**KIRKLEES METROPOLITAN COUNCIL
INVESTMENT & REGENERATION SERVICE**

DELEGATED DECISION TO DETERMINE PLANNING APPLICATIONS

Reference No:	2022/62/91041/W
Site Address:	1, Una Place, Birkby, Huddersfield, HD2 2BQ
Description:	Demolition of existing bungalow and erection of two semi-detached dwellings
Recommending Officer:	William Simcock

DECISION – Conditional Full Permission

rear elevation

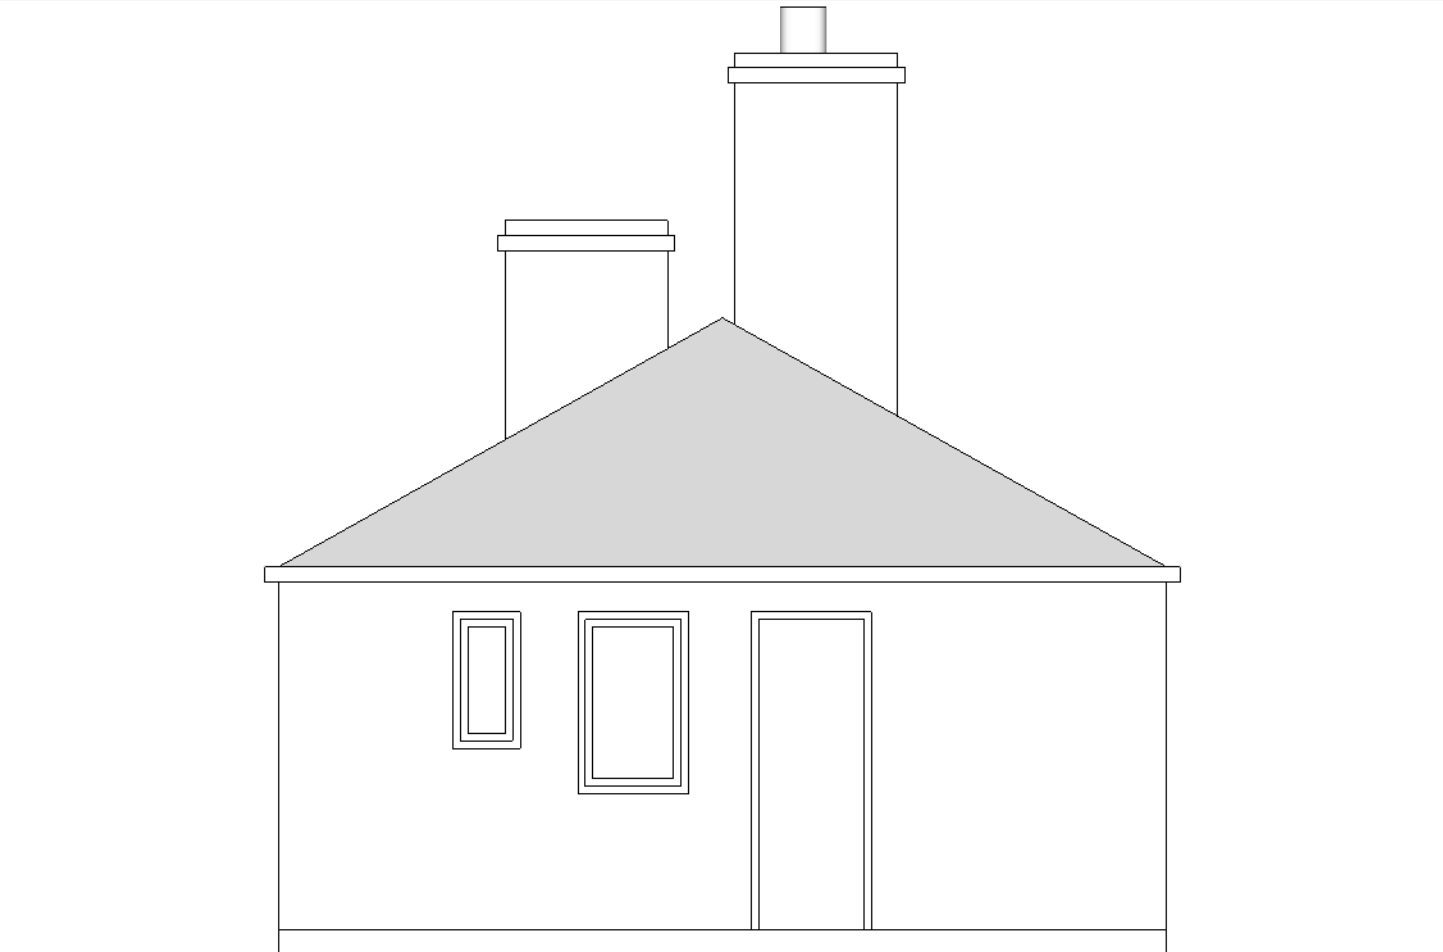
The scheme now under consideration has only bathroom and landing windows facing the rear at first floor. This overcomes one of the principal reasons for refusal (overlooking). Permitted development rights for new windows in the first-floor rear elevation should be removed (or limited to high-level only) by condition to retain the privacy of neighbouring dwellings and future occupiers in accordance with Principle 6 of the SPD, Policy LP24 of the Local Plan and Chapter 12 of the NPPF.

8. Prior to the first occupation of the dwelling hereby approved, all first-floor windows in the rear elevation of the dwellings hereby approved shall be fixed shut, unless parts of the window which can be opened are more than 1.7 metres above the floor level of the room the window is to serve, and obscurely glazed (to give a grade 5 degree of obscurity). Notwithstanding the provisions of section 55(2)(a)(ii) of the Town and Country Planning Act 1990 and the Town and Country Planning (General Permitted Development) (England) Order 2015 (or any order revoking or re-enacting that Act or Order with or without modification), windows of this type shall be retained at all times.

location 1:500

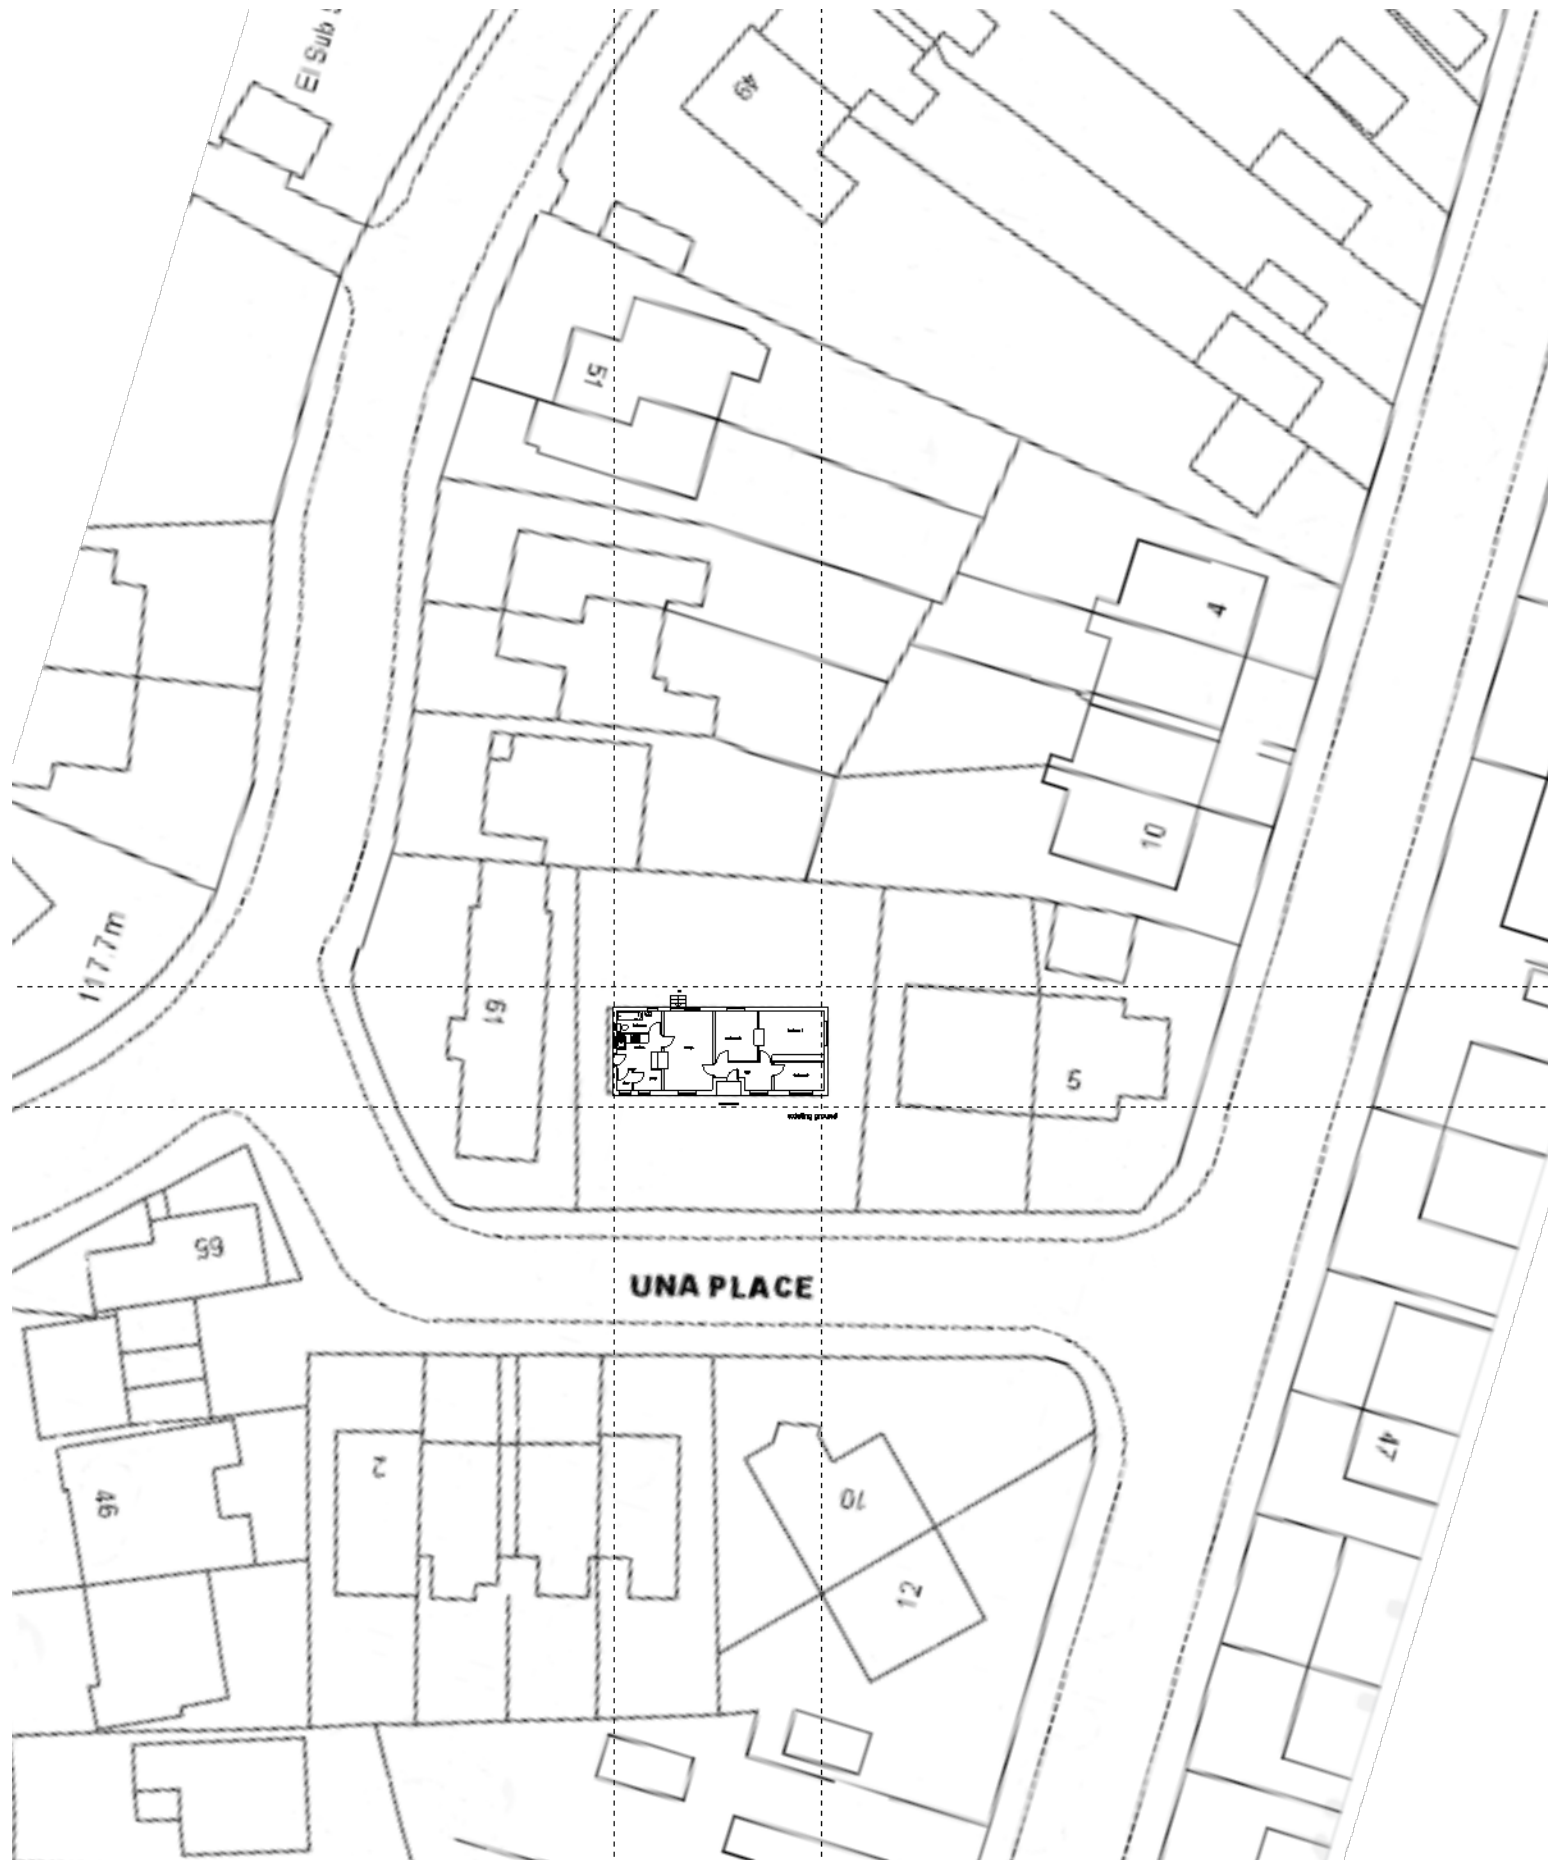
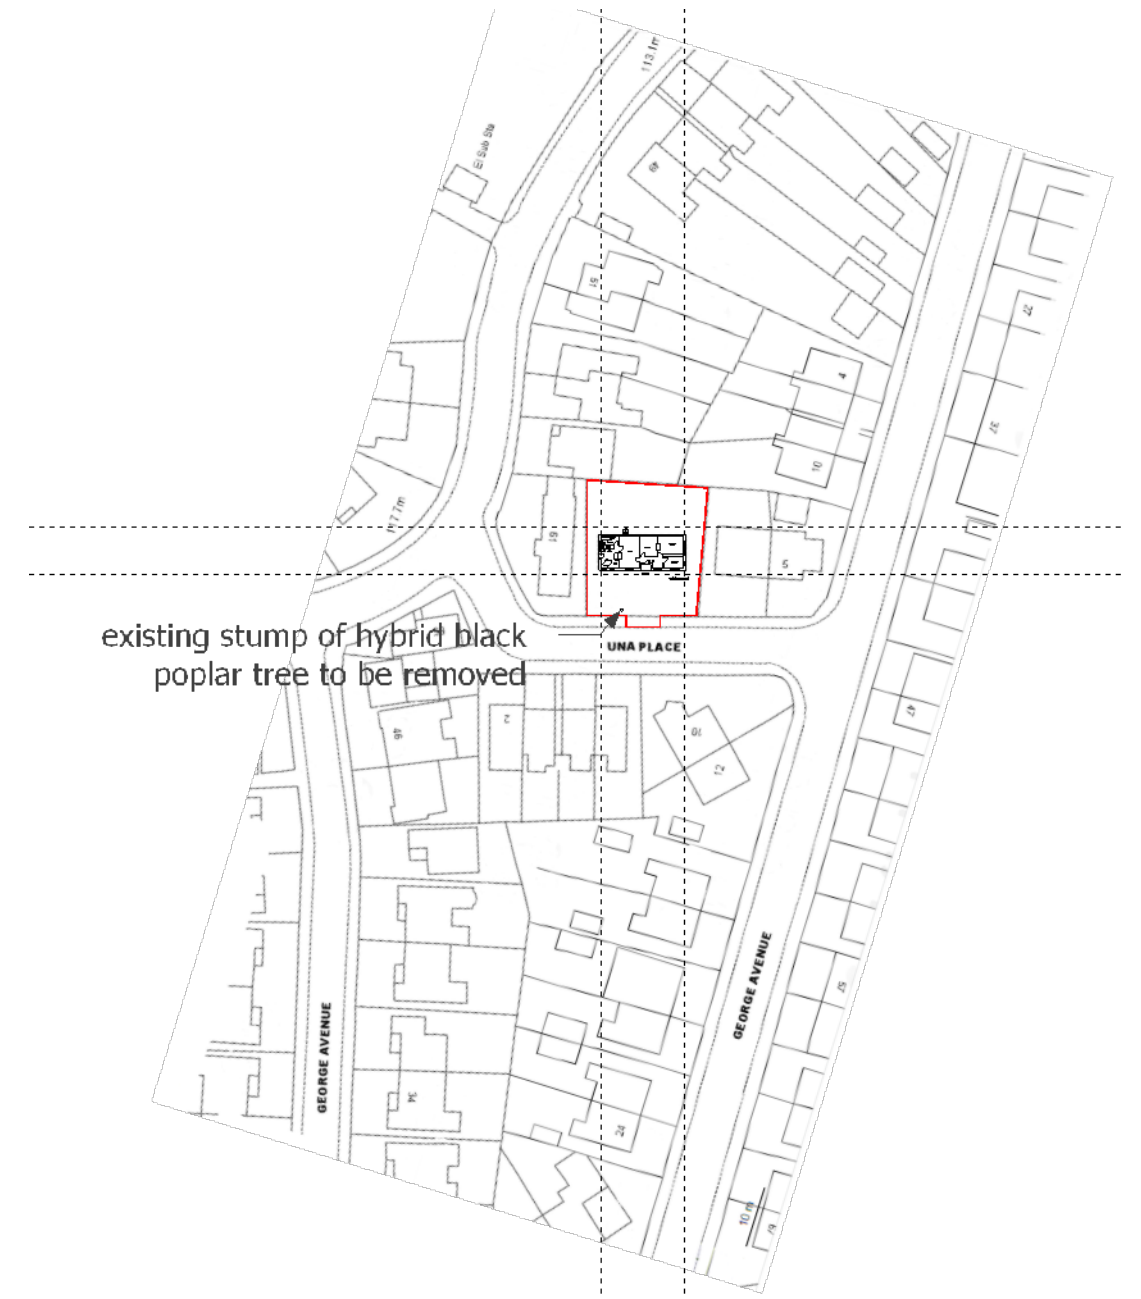
The plans show an enclosure for 2 x 360 litre refuse bins in the front garden. The SPD (Principle 19) accepts that provision of refuse storage facilities at the front of a dwelling may be appropriate as long as their visual impact is minimised. The site plan shows an enclosure around the bins but gives no details. For the avoidance of doubt it is recommended it be conditioned that it is a timber fence of 1m.

Placing the bins against the highway boundary would however be inadvisable as it would create the opportunity for their misuse by passers-by or other local residents who might use them to dispose of litter or domestic waste, thus contaminating the contents. As this is not in the best interests of ensuring the separation of wastes, it is recommended that the bin store should be set back at least 1m from the highway boundary. The architect has agreed to this in principle and has amended the drawing showing each bin store set back 1.5m from the highway boundary. The provision and retention of the arrangements shown on the plans can be conditioned.

7. The facilities for the storage of wastes as shown on Drawing No. 99 Revision C shall be provided and laid out with a hardened and drained surface before the dwelling to which it relates is first occupied. The bin enclosure shall consist of a timber fence of 1m in height. These facilities shall thereafter be retained as such and kept clear of all obstructions to their use for the storage of refuse containers.
